# Response to Submissions Documentation

## Waterloo South

Revision B

21 August 2026

Block 8
Proposed Envelope -
Section 01

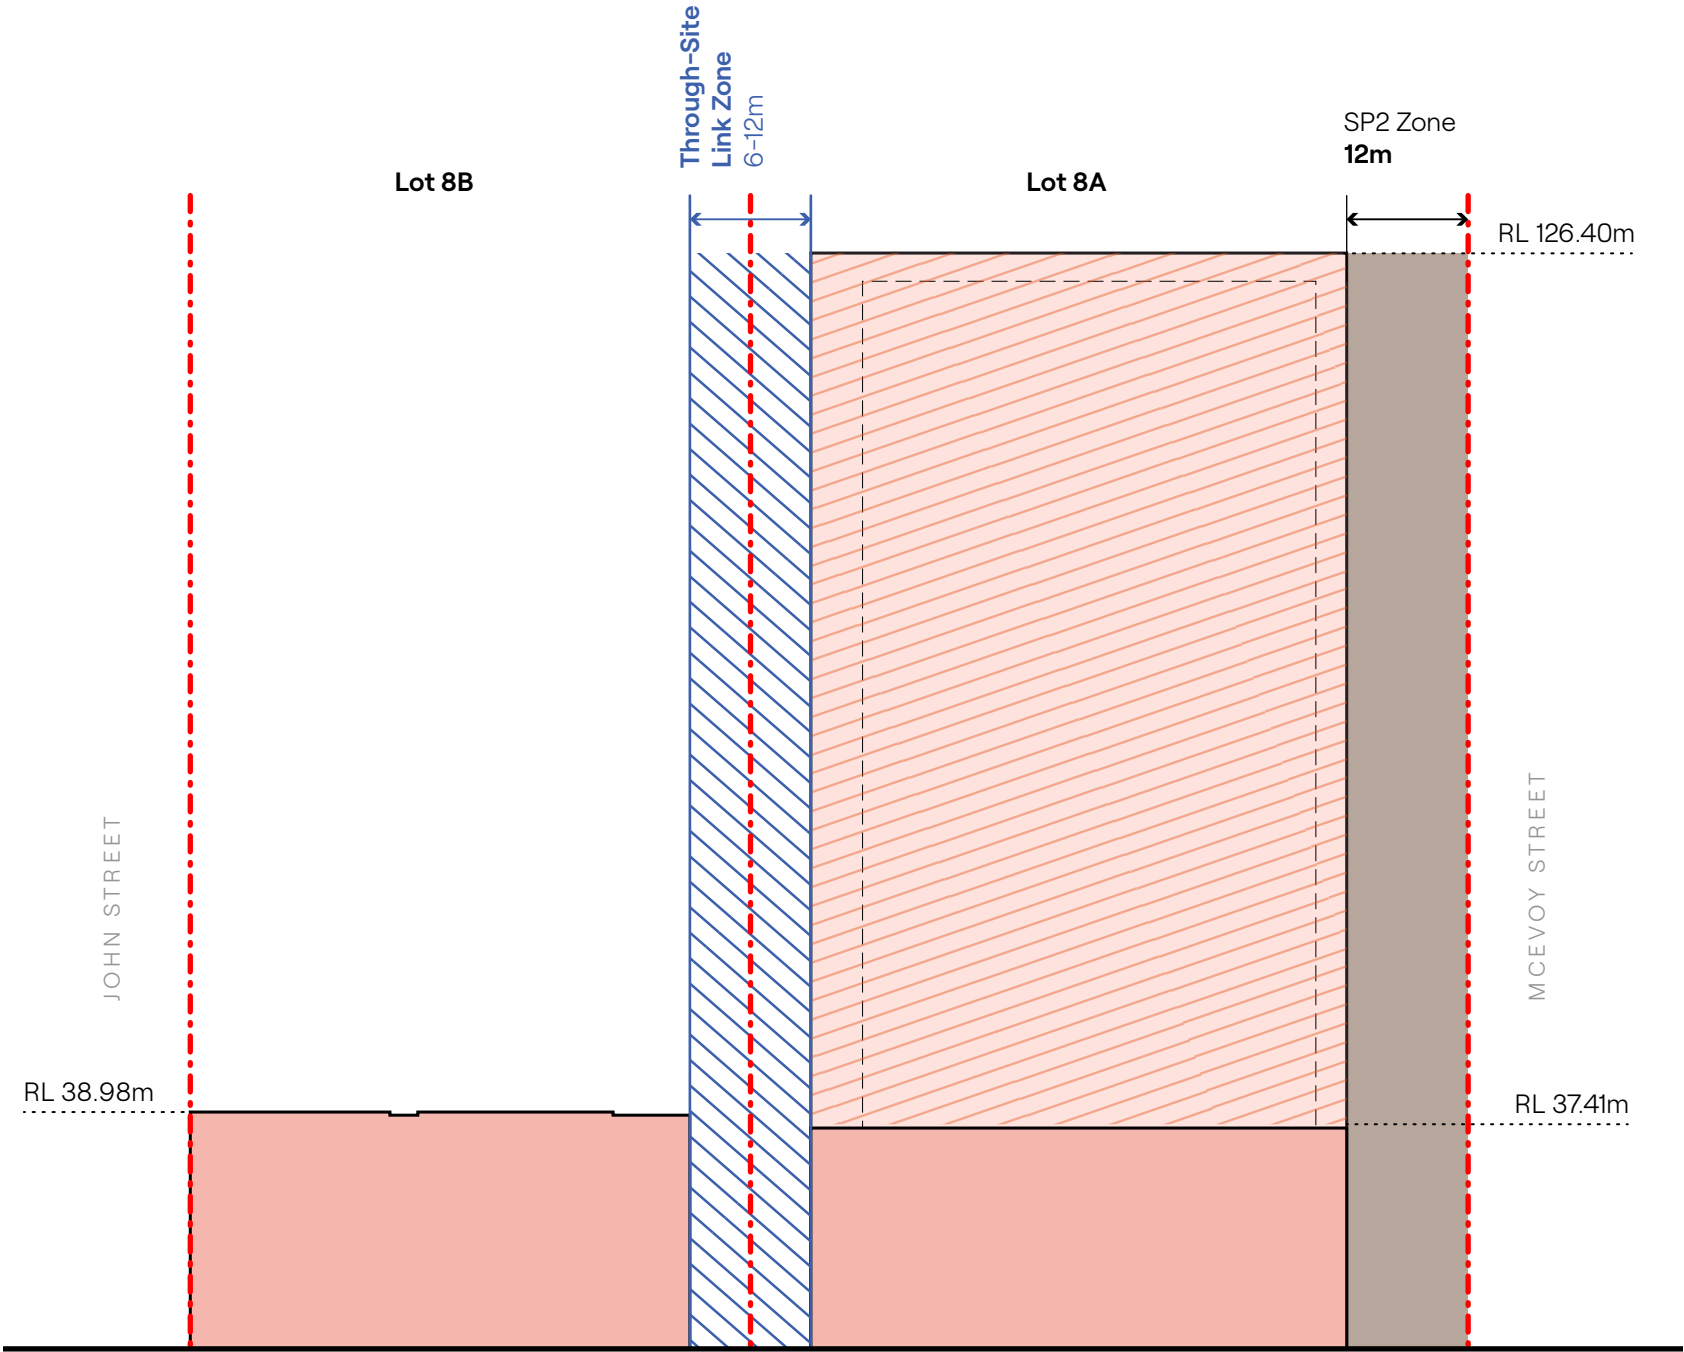
| Agency                                 | Summary of Key Issues                                                                                                                                                                                                                                                                                                                                                                                                                                                                                                                                                                                                                                 | Response                                                                                                                                                                                                                                                                                           | Supporting RtS Documentation |
|----------------------------------------|-------------------------------------------------------------------------------------------------------------------------------------------------------------------------------------------------------------------------------------------------------------------------------------------------------------------------------------------------------------------------------------------------------------------------------------------------------------------------------------------------------------------------------------------------------------------------------------------------------------------------------------------------------|----------------------------------------------------------------------------------------------------------------------------------------------------------------------------------------------------------------------------------------------------------------------------------------------------|------------------------------|
| DPHI<br>Stockland                      | <p><u>Through-site links</u></p> <p>The Department understands Homes NSW is redesigning block 8 to reintroduce a southern through-site link to improve permeability and address CPTED concerns. The Department supports this approach and requests the through-site link to be reinstated and reflected consistently across the DG and Concept Plan.</p>                                                                                                                                                                                                                                                                                              | <p>Southern through-site link on Block 8 added to envelope drawings.</p>                                                                                                                                                                                                                           |                              |
